Priory Farmhouse, Freefolk Priors, Freefolk

Appendix 1 - Heritage Impact Drawings

Appendix 2 - Commentary on Pre-Application Advice

PROPOSED UTILITY ENTRANCE

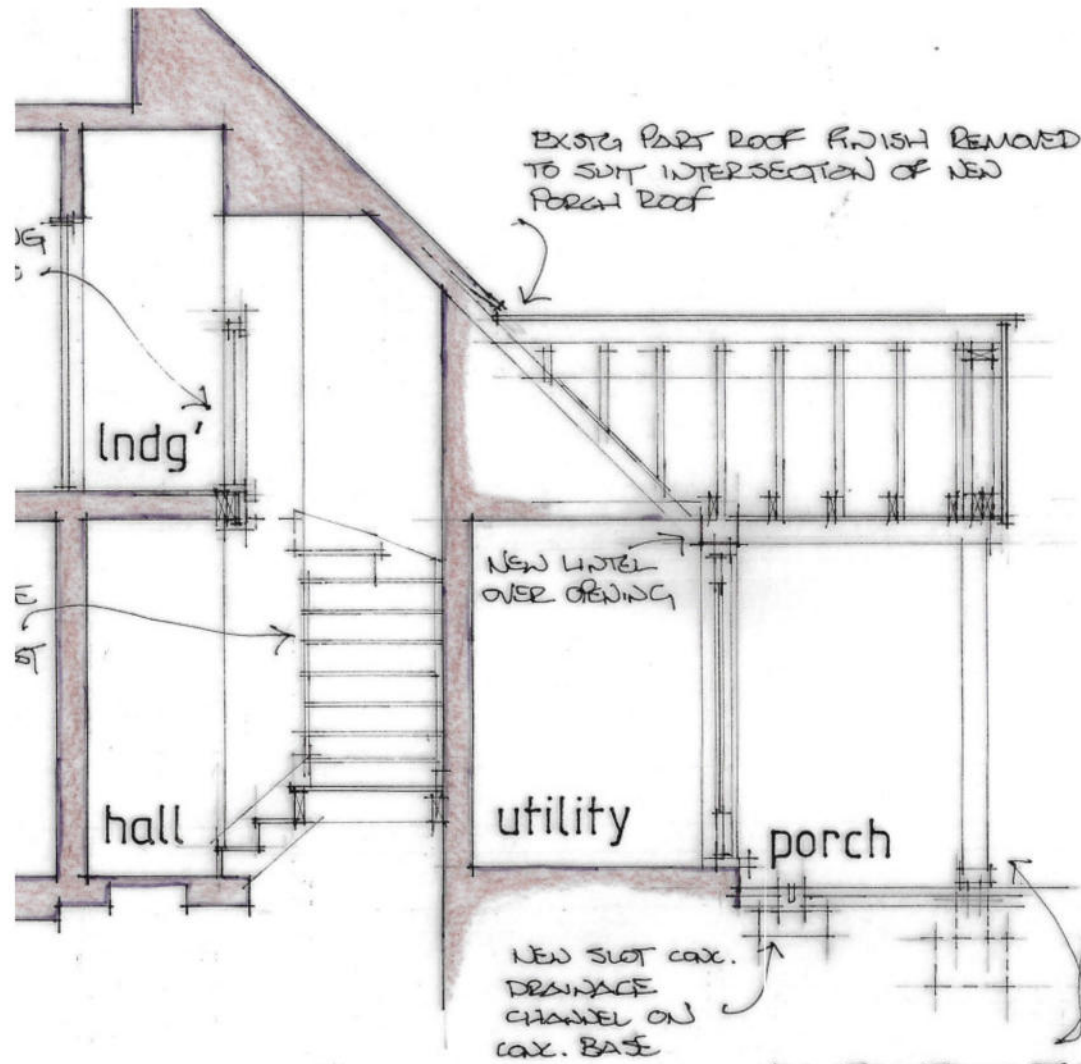
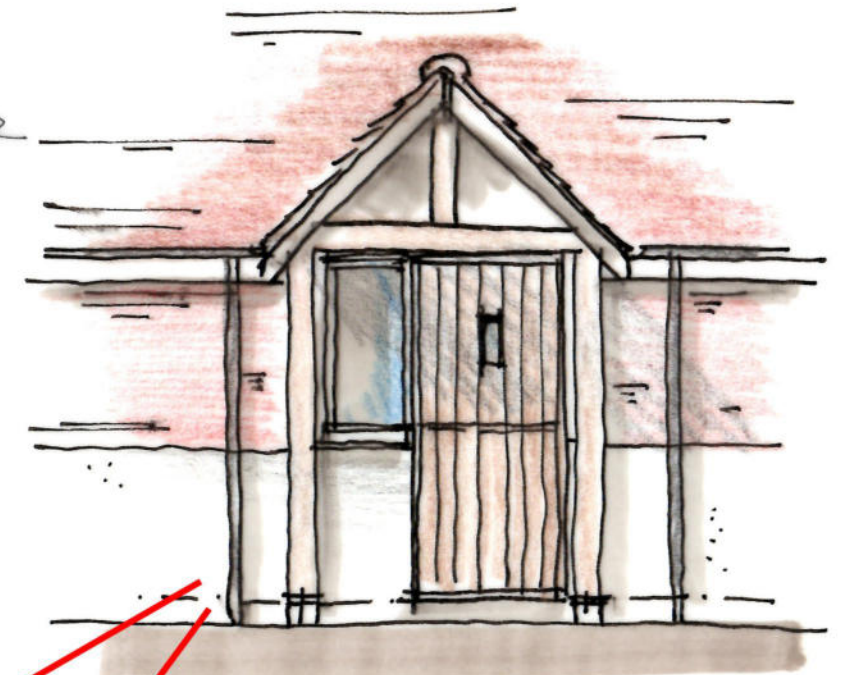
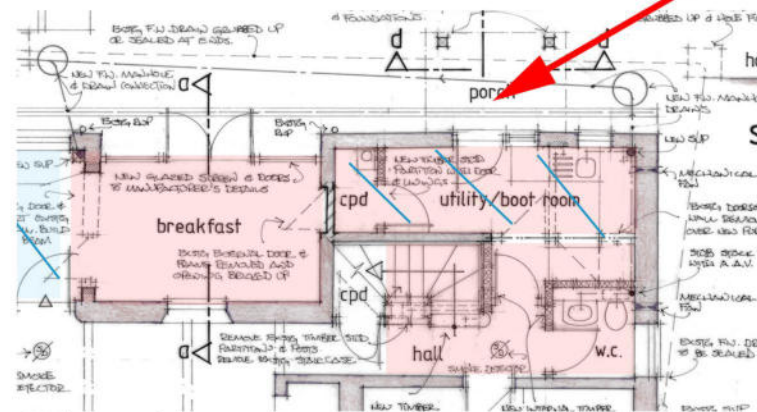
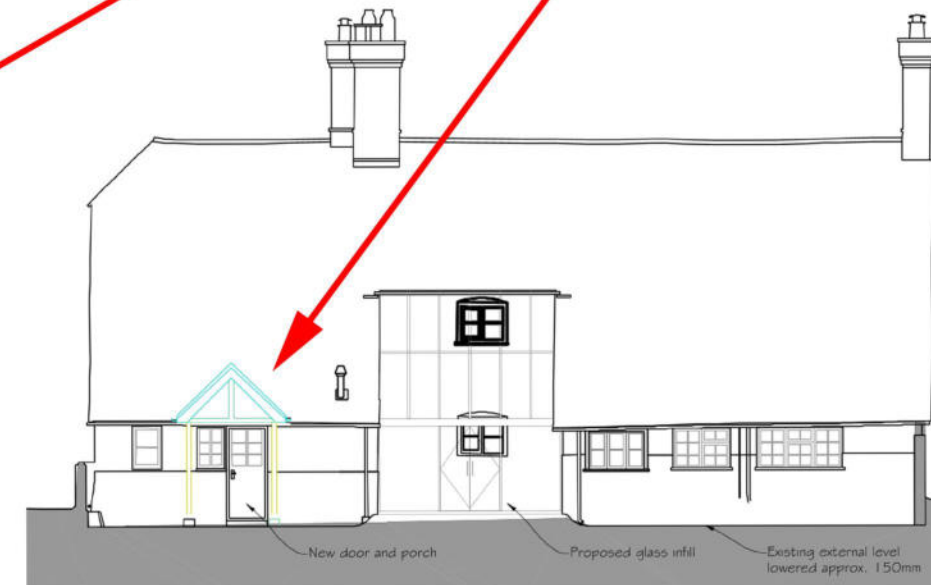
I think that the works to the ground floor utility area and corridor are unlikely to have adverse impacts on the significance of the building. I would recommend some form of mechanical ventilation for the new bathroom (and any other bathroom in the building). Care will need to be taken in how the external vent terminals are detailed. The new en-suite to bedroom 1 may prove tricky to address, due to the lack of an external wall.

The existing utility and wc areas are shown combined (to form a new boot/utility room) with new back door.

The changes are limited to the removal of more recent fabric in the lean-to construction.

Section C-C 1:50

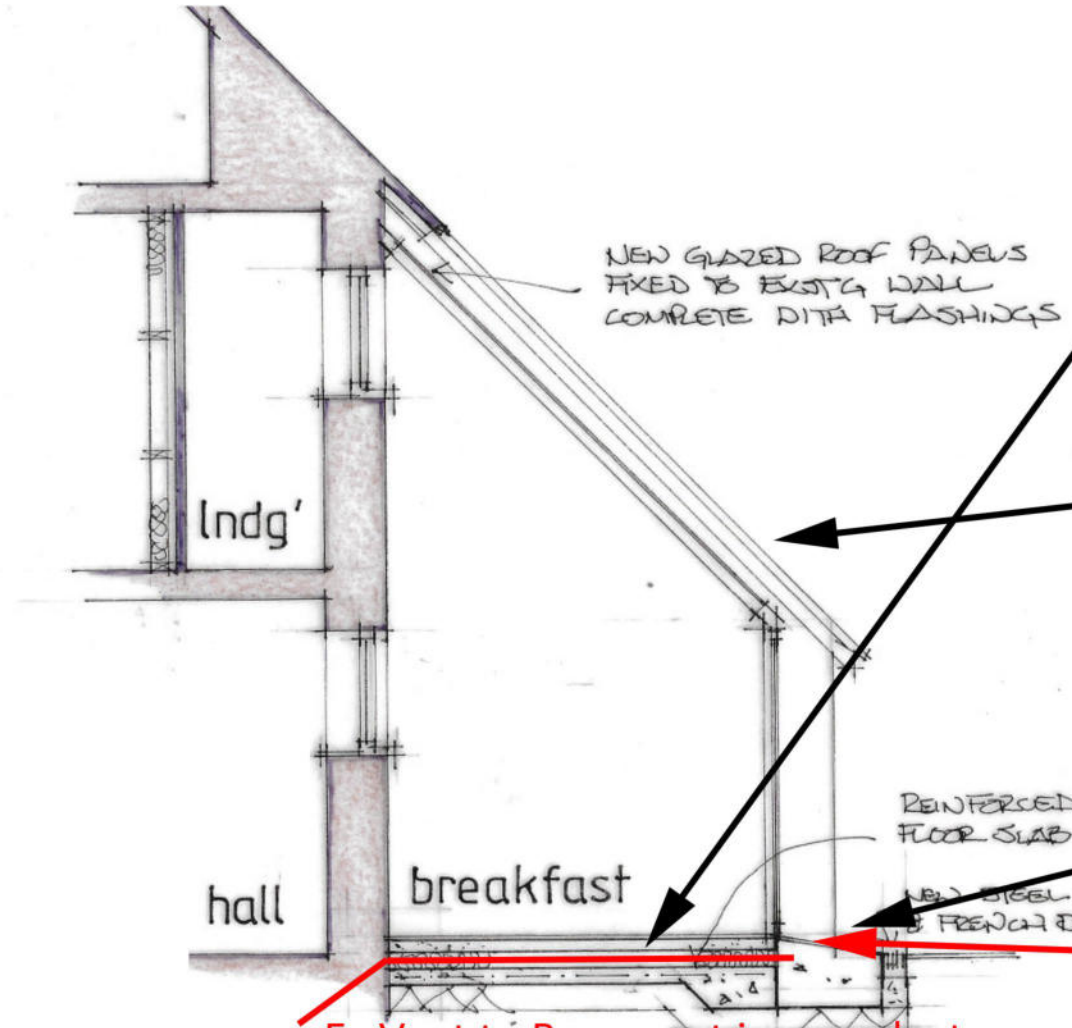
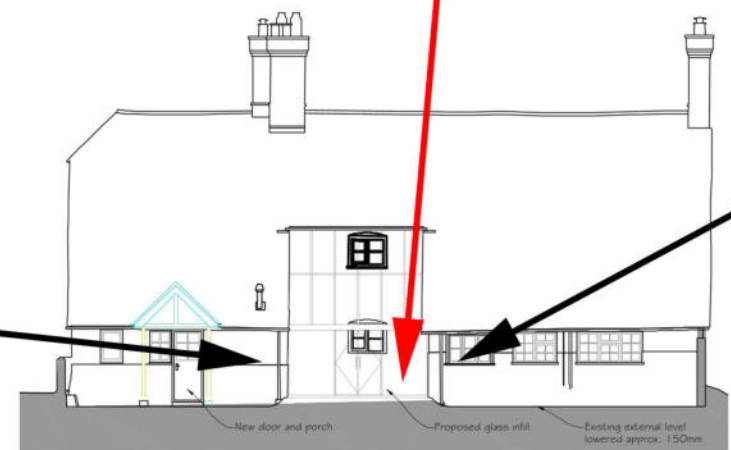
The external alterations to the garden do not seem contentious to me. I would encourage the creation of a French drain.

Proposed extension would seem to relate to the form of the building. Timber framing is part of local vernacular, but not prominent on the exterior of this building. 'Chunky' timber framed glazing could look visually heavy. Suggest that a visually lightweight glazed extension could be appropriate – clearly contemporary addition to the building, which, if detailed sensitively, should sit comfortably with listed building.

It is proposed to reduce external paved areas adjacent to the rear of the farmhouse – with a perimeter French drain as part of works to form a gentle ramped access from the parking area.

A contemporary glazed structure is proposed
